Application for a Non-Material Amendment Following a Grant of Planning Permission

Erection of a one and a half storey side and rear extension; Raising pitch of roof of dwelling and construction of front and rear dormer windows including side rooflights in conjunction with loft conversion; Erection of attached garage (following demolition of existing detached garage); Erection of a rear conservatory (amended scheme to that approved under DC/19/02883)

DC/22/00608

Changes to external finishes - amendments to where cladding will be installed as shown on attached elevations.

DRG No. 105A

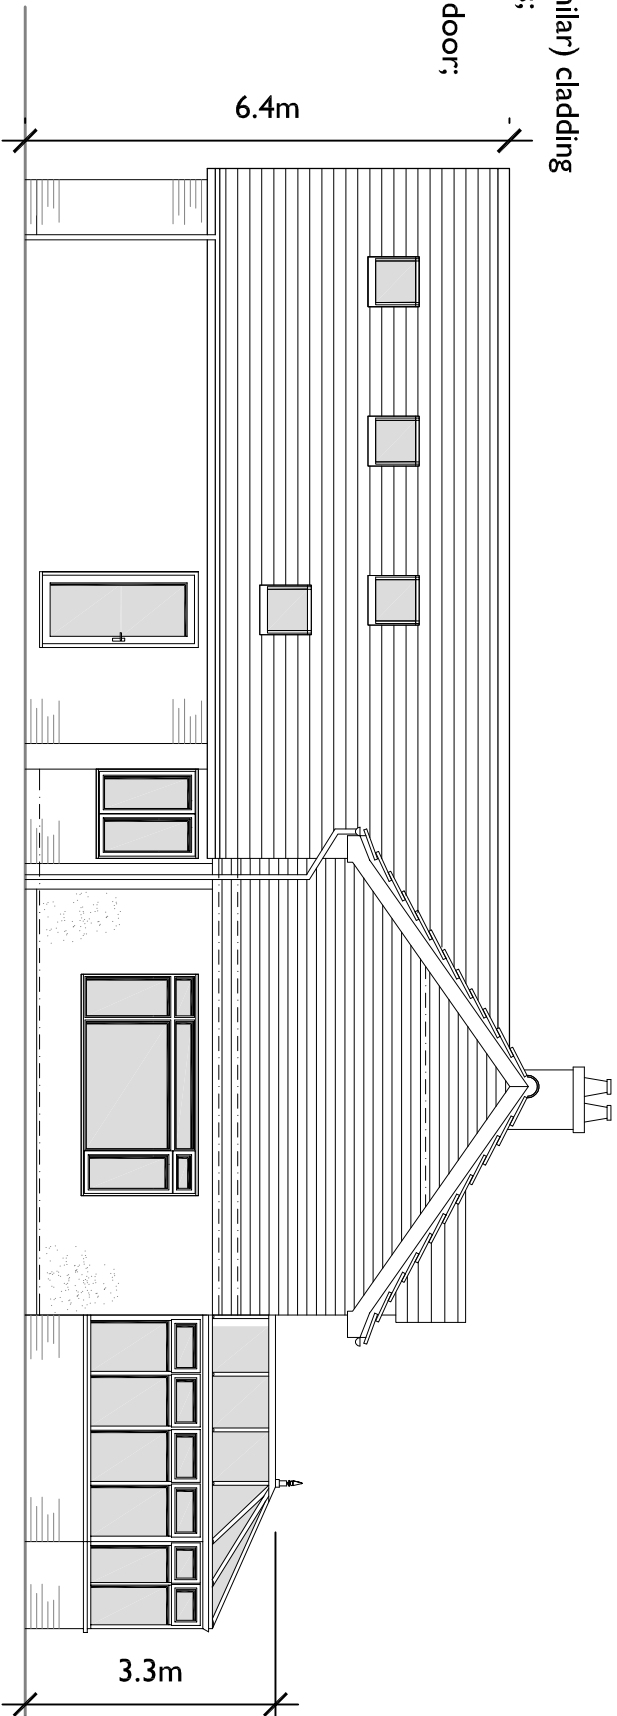
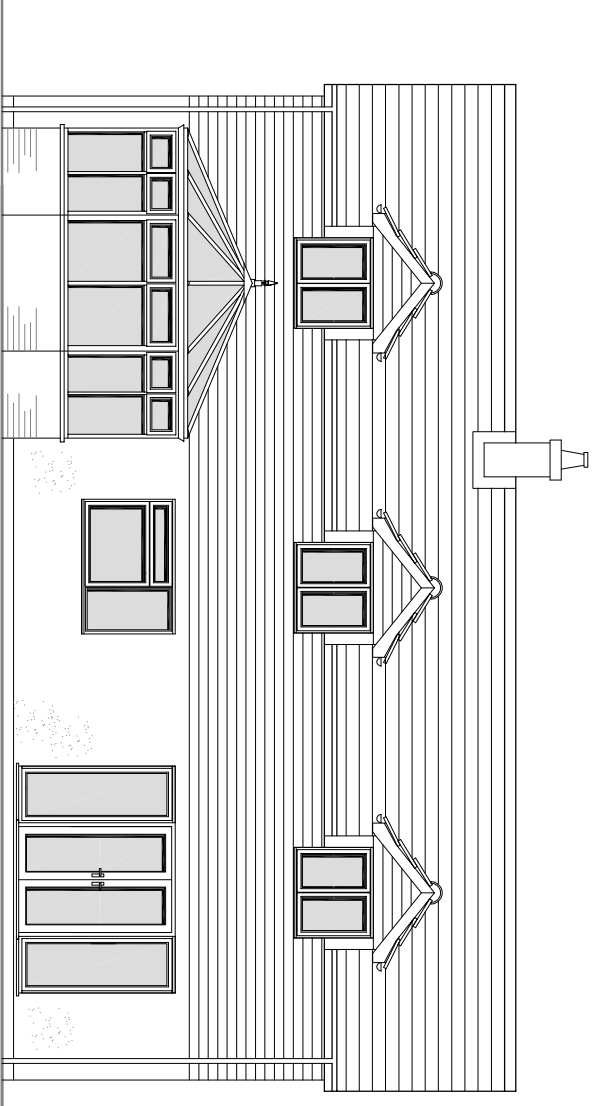
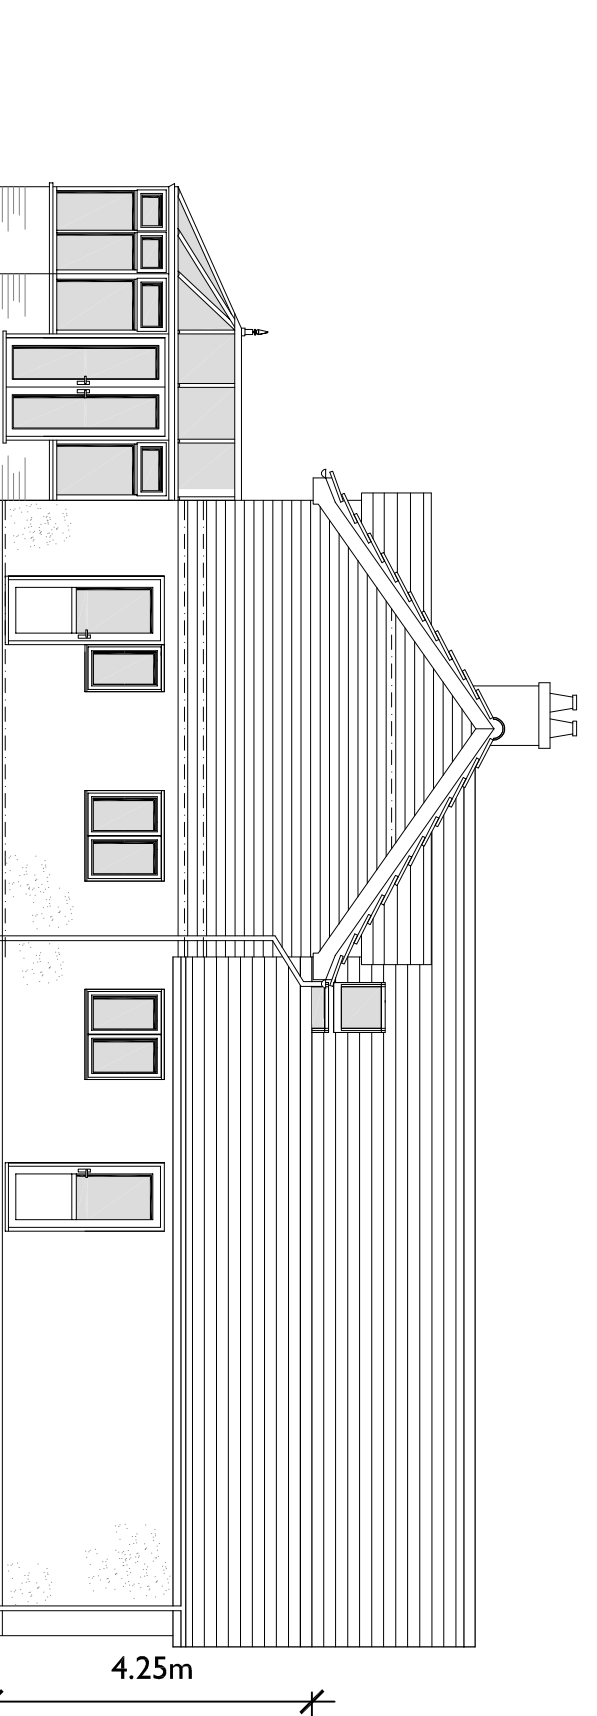
Replacing dormer in bathroom to a rooflight on front elevation.

Both changes have come about during construction. The changes to the cladding is to save costs and enable the cladding and render joint to meet where the timber framed first floor finishes.

The change to the dormer window is a practical one as the dormer would clash with the valley of the raised roof of the original bungalow. A rooflight will avoid any complications.
